Item No. **Report of the Head of Planning, Sport and Green Spaces**

Address BELMONT HOUSE (FORMERLY SENATOR COURT) BELMONT ROAD
UXBRIDGE

Development: Application for a non-material amendment to planning permission Appeal
Ref: APP/R5510/A/13/2199431 dated 26/03/2014 to allow for amendments to
the landscaping along Belmont Road (Part demolition, part extension and
refurbishment of existing building to provide 13,150sq.m GIA of office
accommodation (Use Class B1(a)); 516sq.m GIA to be used interchangeably
for Class A1, A2, A3, and B1(a); basement car park; plant areas and
associated works)

LBH Ref Nos: **68385/APP/2016/100**

Belmont Road Frontage
Landscaping Plan
1 of 2

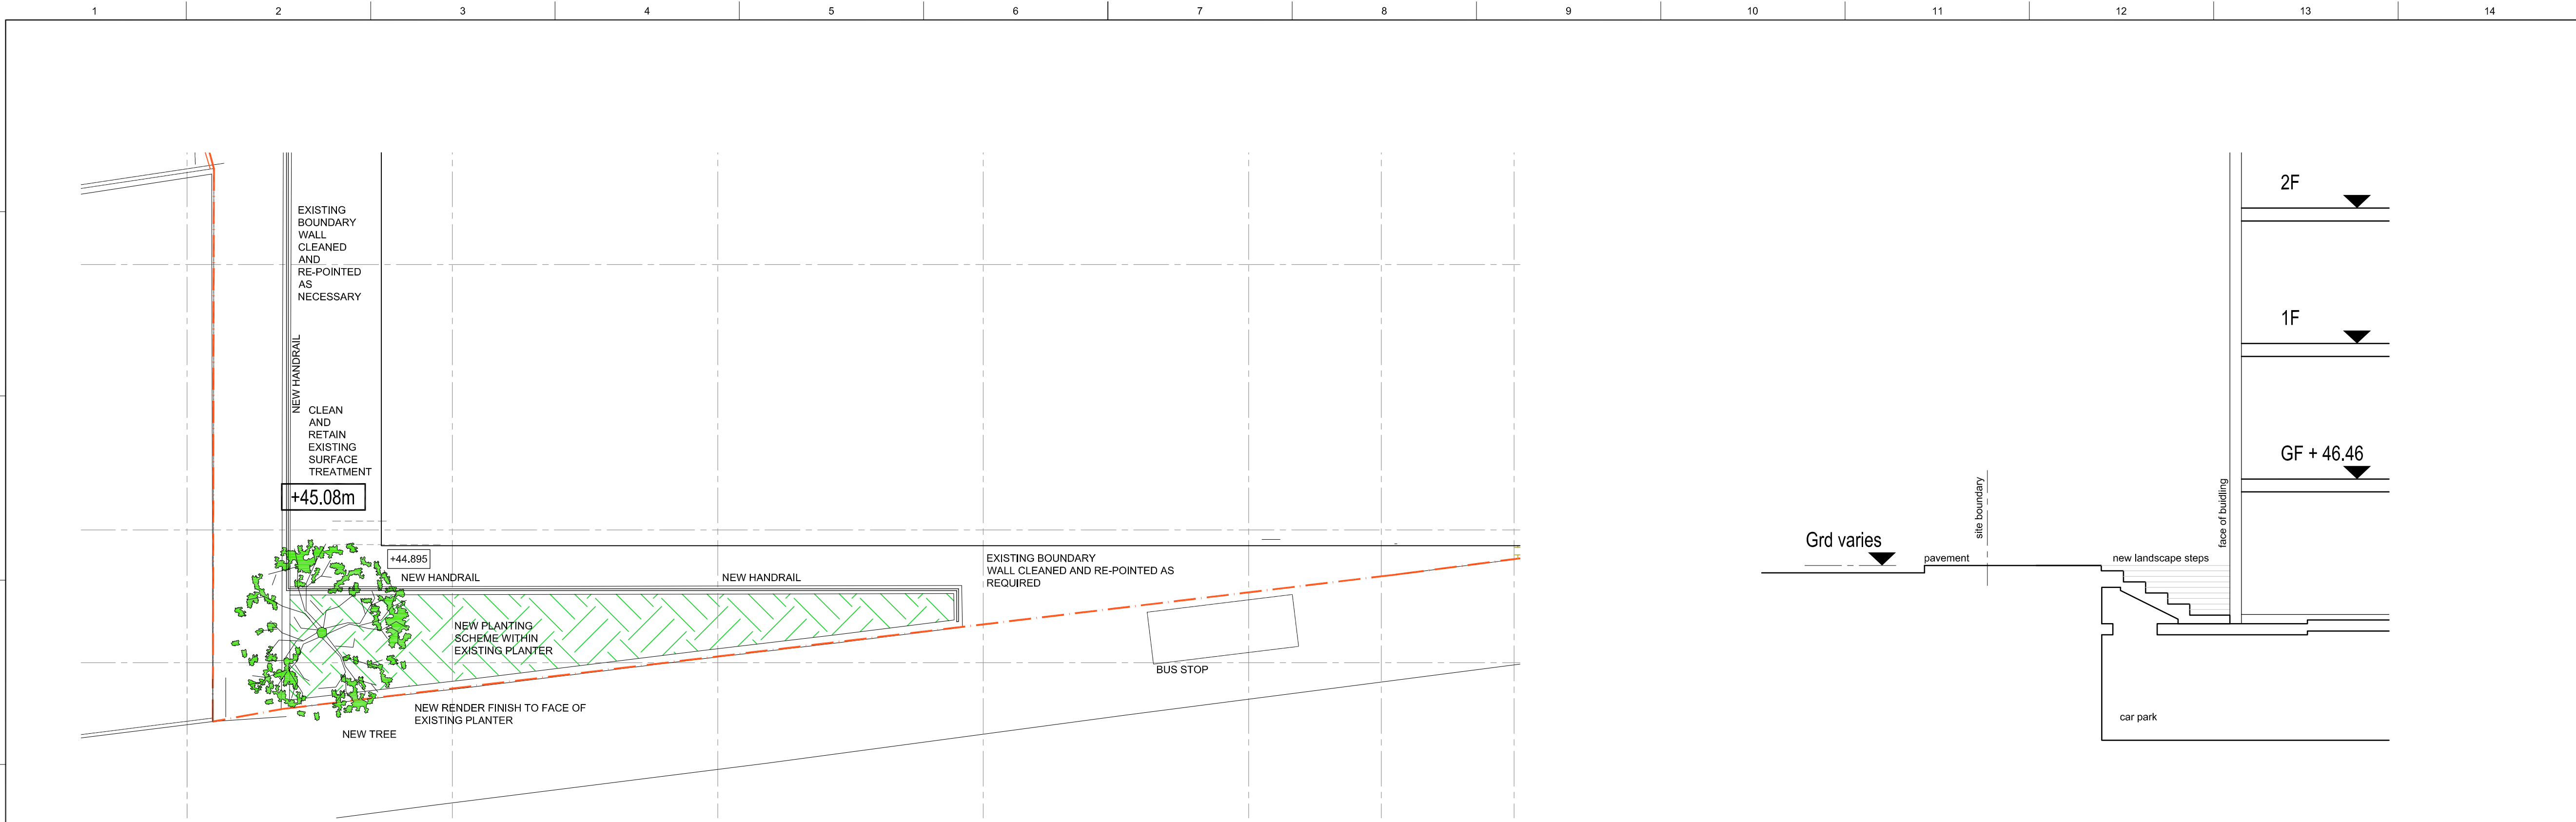
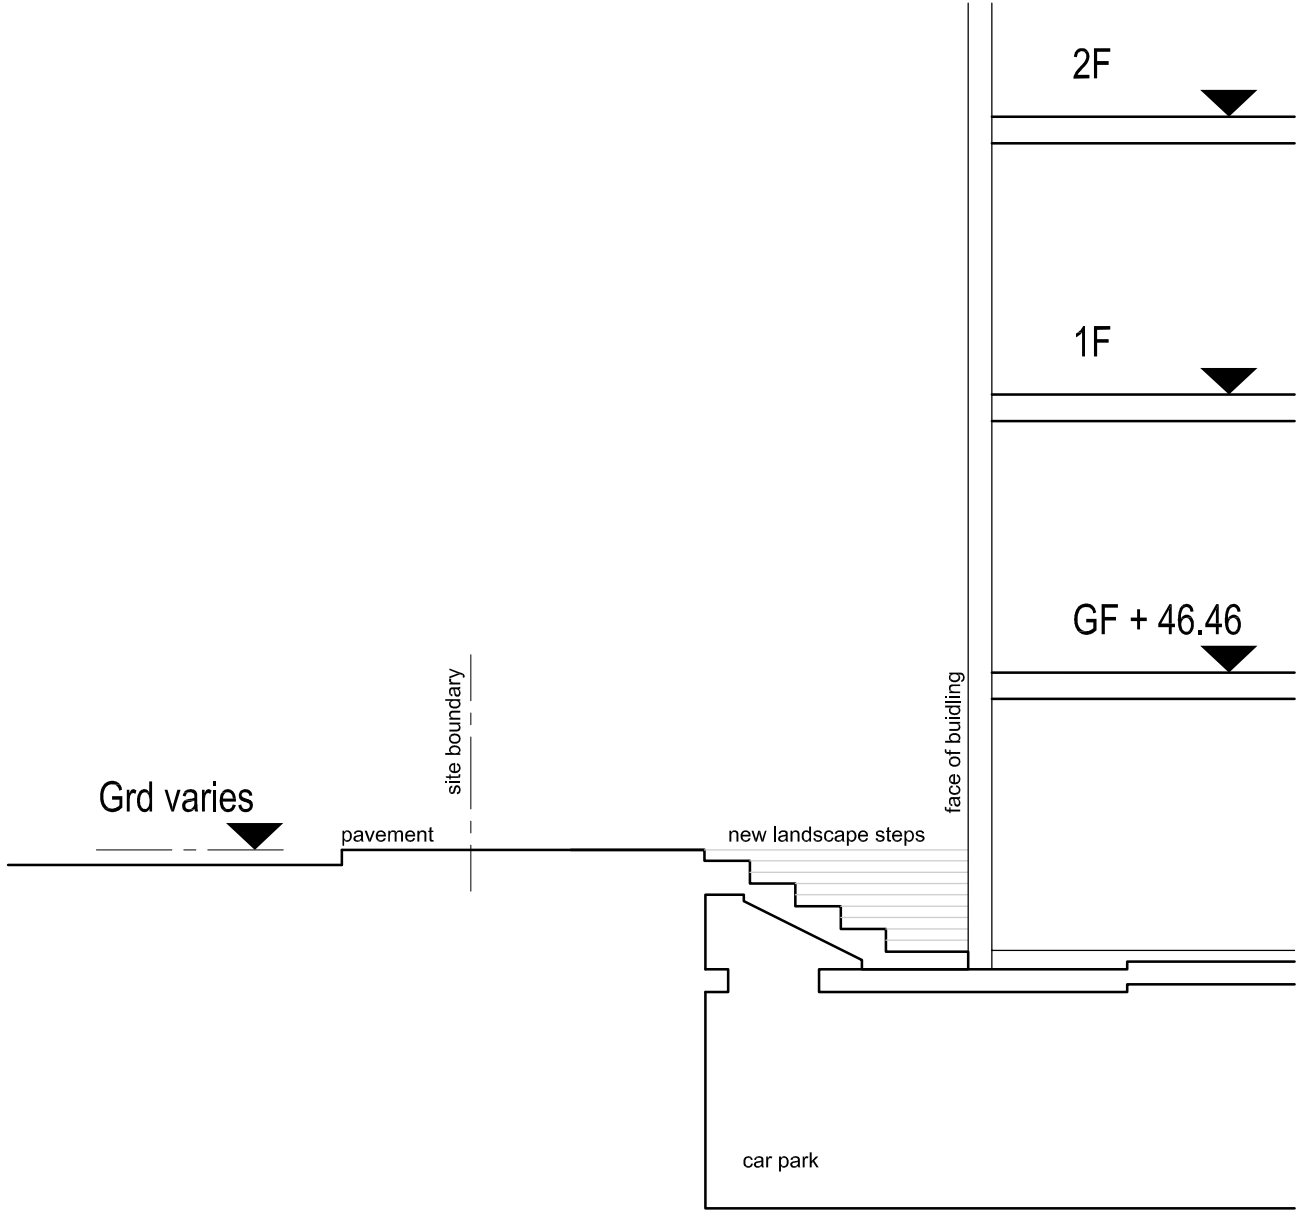
The current submitted drawing TP Bennett drawing No. D14000 Rev P2 is based on an old drawing which does not accurately indicate the landscape details that were subsequently approved for the site frontage under application reference 68385/APP/2015/1494. For example much discussion has taken place concerning the condition of the street tree labelled 'TREE RETAINED'. This tree is dead and due to be removed and replaced.

The Council's Landscape officer has advised that a 'structural' tree pit (with increased volume of soil under the footway) is to be constructed to support a replacement tree - as noted in Barton Wilmore's drawing No. RG-L-04, submitted in support of application ref. 68385/APP/2015/1218, which was granted permission subject to conditions which included the following:

In order to satisfy the landscape condition, full hard details (tree pit design and construction) and soft details planting plans with supporting documents are required.

The proposed amendments to the landscaping involving the loss of the tree planting which was originally considered necessary by the Inspector, given the nature of the subsequent planning history which include a number of conditions, along with the submitted plans not accurately reflecting the most recently approved plans under application references 68385/APP/2015/1494 and 68385/APP/2015/1218, are considered to be material in nature.

The proposed plan reference D 14000 Rev P2 conflicts with subsequent planning permissions at this application site. In order to satisfy the landscape condition in respect of planning permission 68385/APP/2015/1218, full hard details (tree pit design and construction) and soft details planting plans with supporting documents are required to be considered. The removal of the tree planting as proposed is not considered to be non-material in nature and would be in conflict with Policy BE38 of the Hillingdon Local Plan: Part Two - Saved UDP Policies (November 2012).
